Meeting:	Borough Planning Committee	
Date:	Thursday 10th March 2022	Time: 6:00pm
Venue:	Committee Room 5, Civic Centre

ADDENDUM SHEET

Item:	Page:	Location: Gidar House
Amendments/Additional Information:		Officer Comments:
The report states that “ <i>the new window on the rear elevation is to be set low down on the building to serve the staircase, but still above ground floor level</i> ”. The new window does not serve the staircase, it will serve a WC and meter room.		This is a point of clarification which does not change the recommendation or assessment. The condition to permanently fix and obscure this window remains reasonable and necessary in all respects.
		Location: Neyland Court
Amendments/Additional Information:		Officer Comments:
The report states in section 6 that comments were received from the Eastcote Residents’ Association. This has been noted in error and the objections have been received from the <u>Ruislip</u> Residents’ Association.

SCALE	DATE		
1:500 @ A3	17.12.21		
	PROJECT NO.		
	15.530	B.10	-

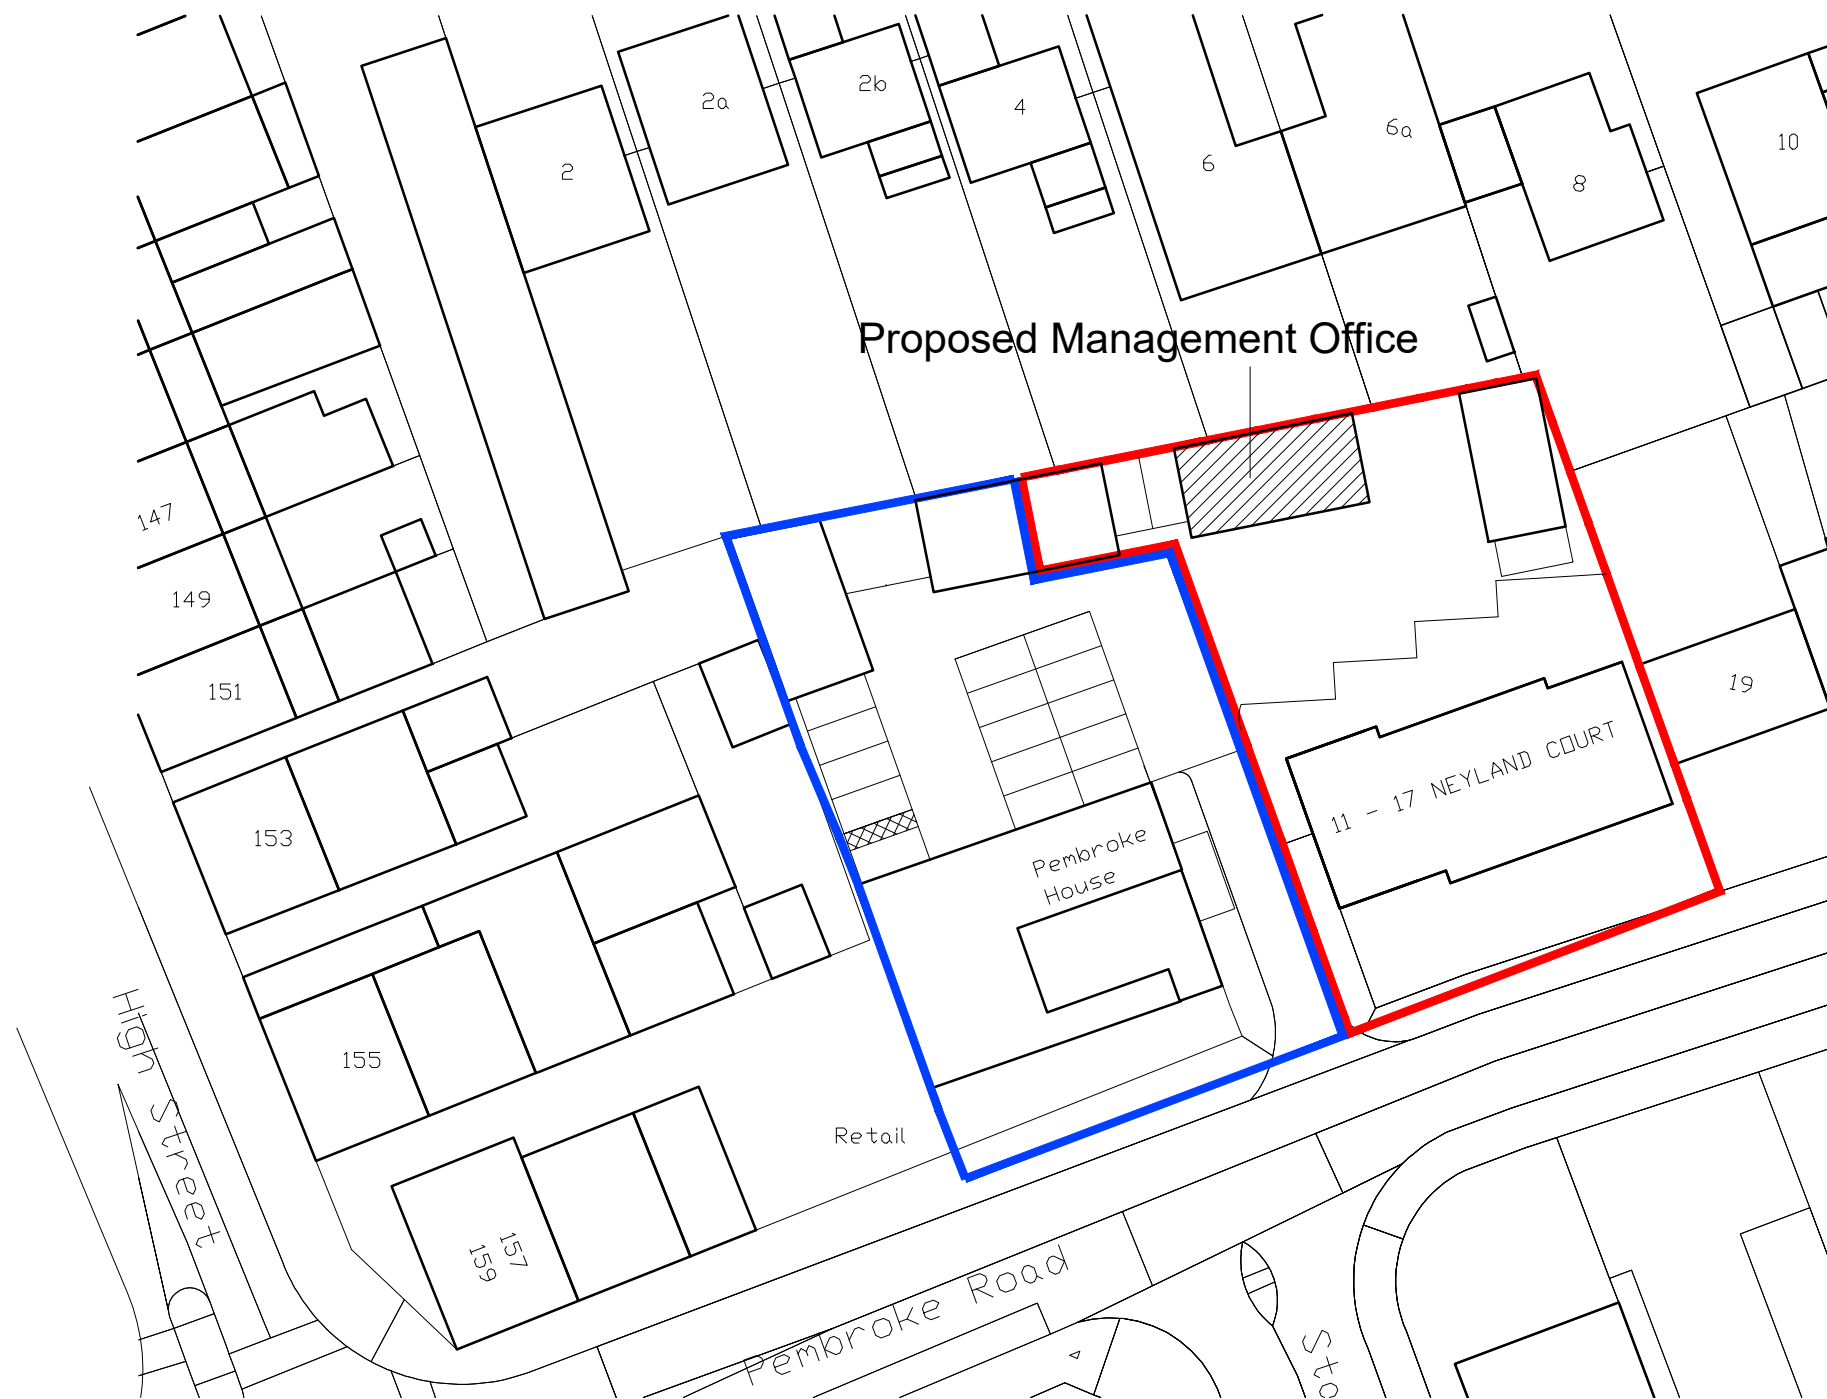
<p>The 'Proposed Site Layout amended' P.11 as shown below is incorrect, and so the amenity space measurements shown cannot be taken seriously.</p> <p><i>Problems with P.11:</i></p> <ol style="list-style-type: none"> 1. The existing garage block is at an angle to the boundary with 19 Pembroke Road, not 21 Pembroke Road as shown on P.11. 2. The bin stores are rectangular in shape as shown in the photo above. So the green shaded area to represent "22.4 sqm amenity gained" is overexaggerated as it includes existing amenity space south of the bin store wall where there is a tree at the boundary with no 19 some landscaping and grass. (See photo above). 3. P.11 does not indicate the existing tree highlighted in pink on the plan above and in two photos above. The proposals suggest it will have to be removed to build the "proposed new low level wall". 4. P.11 does not indicate where the residents will have to walk across the reduced depth amenity space behind Neyland Court to access the "New Access Gate" to get to the new refuse store. 5. No details of the new landscaping or location of a replacement tree! 6. The Three parking spaces for residents of Neyland Court are not identified <p><i>Conclusion:</i></p> <p>The RRA supports local residents in opposing these amended proposals for the following reasons:</p> <ol style="list-style-type: none"> 1. Policy DMHB 11 of the Hillingdon Local Plan: Part 2 – Development Management Policies (the DM) requires, amongst other matters, that new development incorporates the principles of good design and takes into account the effect on neighbouring open spaces and environment and "should not adversely impact on the amenity, daylight and sunlight of adjacent properties and open space". <p>The proposed new low wall with railings will provide less privacy or protection from noise and pollution from vehicles (mostly not owned by residents of Neyland Court) in the carpark, and the design is not characteristic of the original design of Neyland Court. Therefore, the proposed new layout with low wall would harm the living</p>	<p>employees or clients who have mobility issues as it can only be accessed by a central staircase to the first floor. Given these circumstances and noting the associated planning history, it would not be appropriate to require the provision of disabled car parking spaces.</p>

There is still no car park layout plan to indicate the location of the three allocated spaces for Neyland Court residents, disabled spaces or electric charging points. Given that the garage block is incorrectly located on the plan it is impossible to assess if all parking spaces shown on the plans can be practically accessed by a vehicle.
